# PORTLAND MAINE

February 15, 2011

RE: 83 Madeline Street – R-3 Zone – 180-D-001 & 021

Building Permit Set  
C-1.1

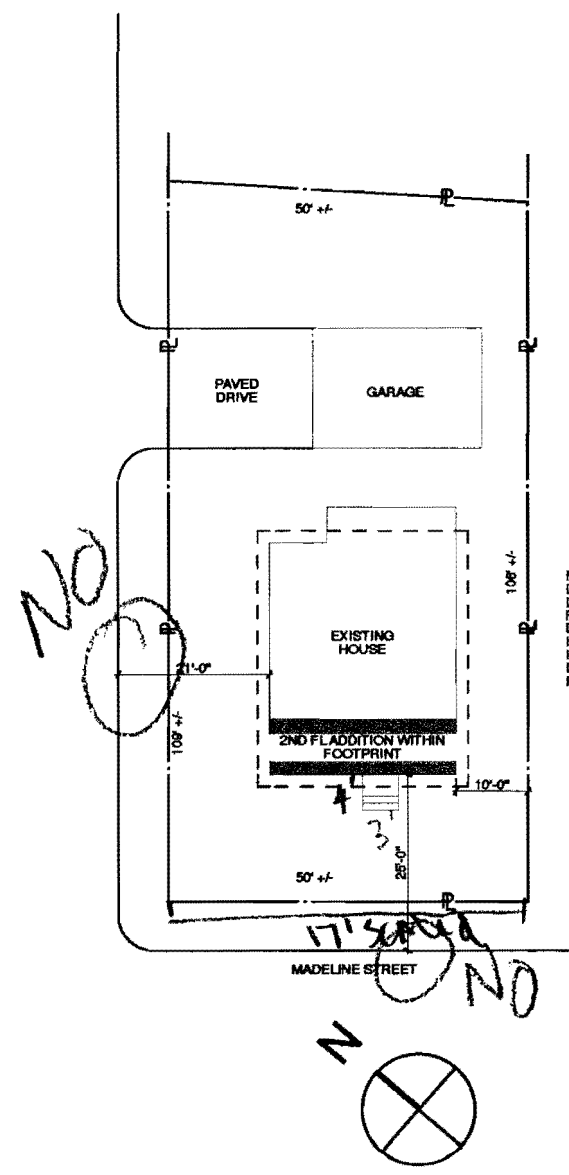
First of all the submitted plot plan is not accurately showing setbacks. Portland's required setbacks are always measured to property lines, not apparent curb lines. Your submitted plot plan should be revised to show the correct setbacks. The submitted plot plan is not to scale. The submitted plans should be scalable. It is difficult for me to know the size of the new front entryway and how it is meeting the setbacks and requirements.

**1** West Elevation  
SCALE: 1/4" = 1'-0"

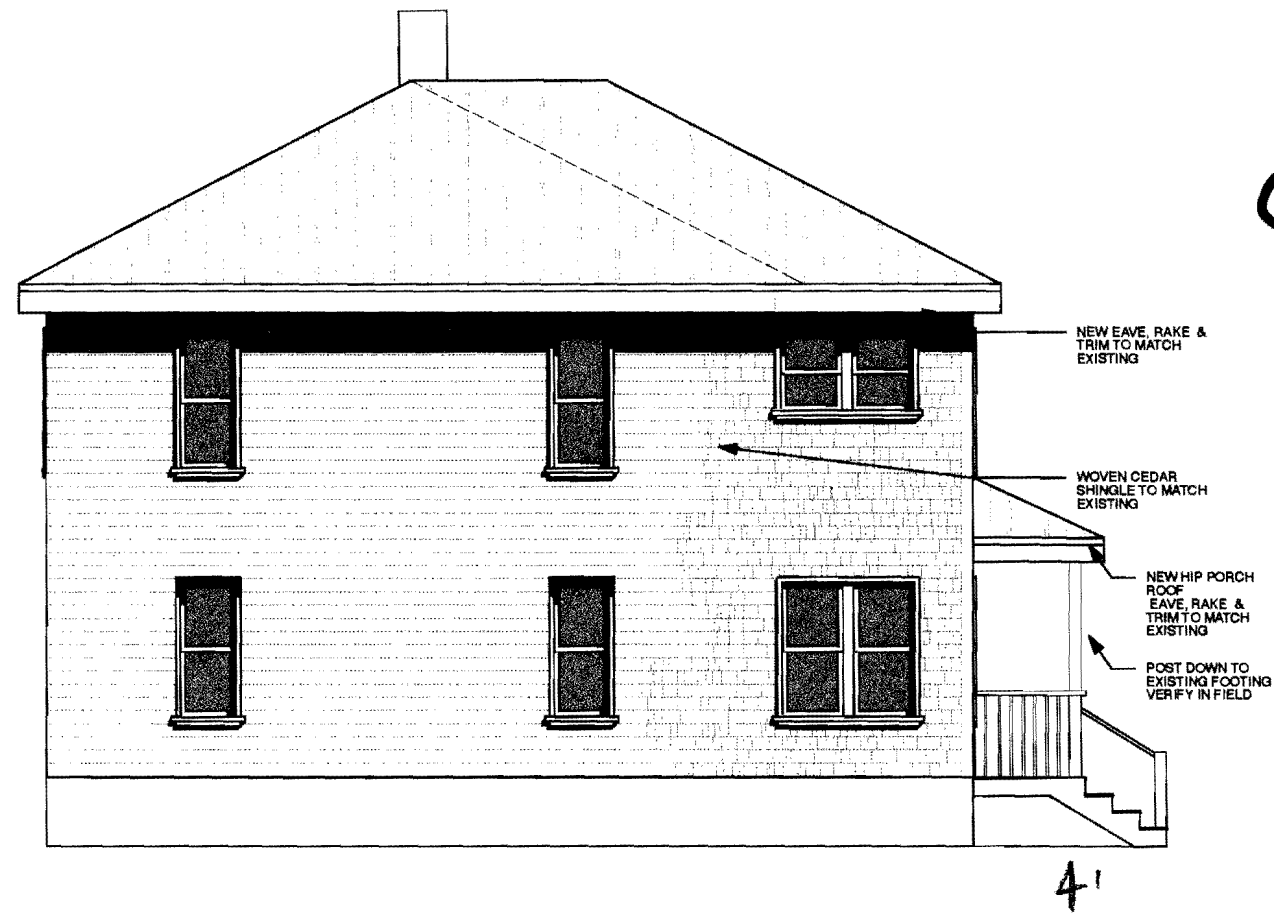
Your proposal is not meeting the requirement to create additional floor area in the uppermost floor. The new area is at a lower level above a front porch. The existing roof configuration of the front porch is being altered and not meeting another criteria of the ordinance.
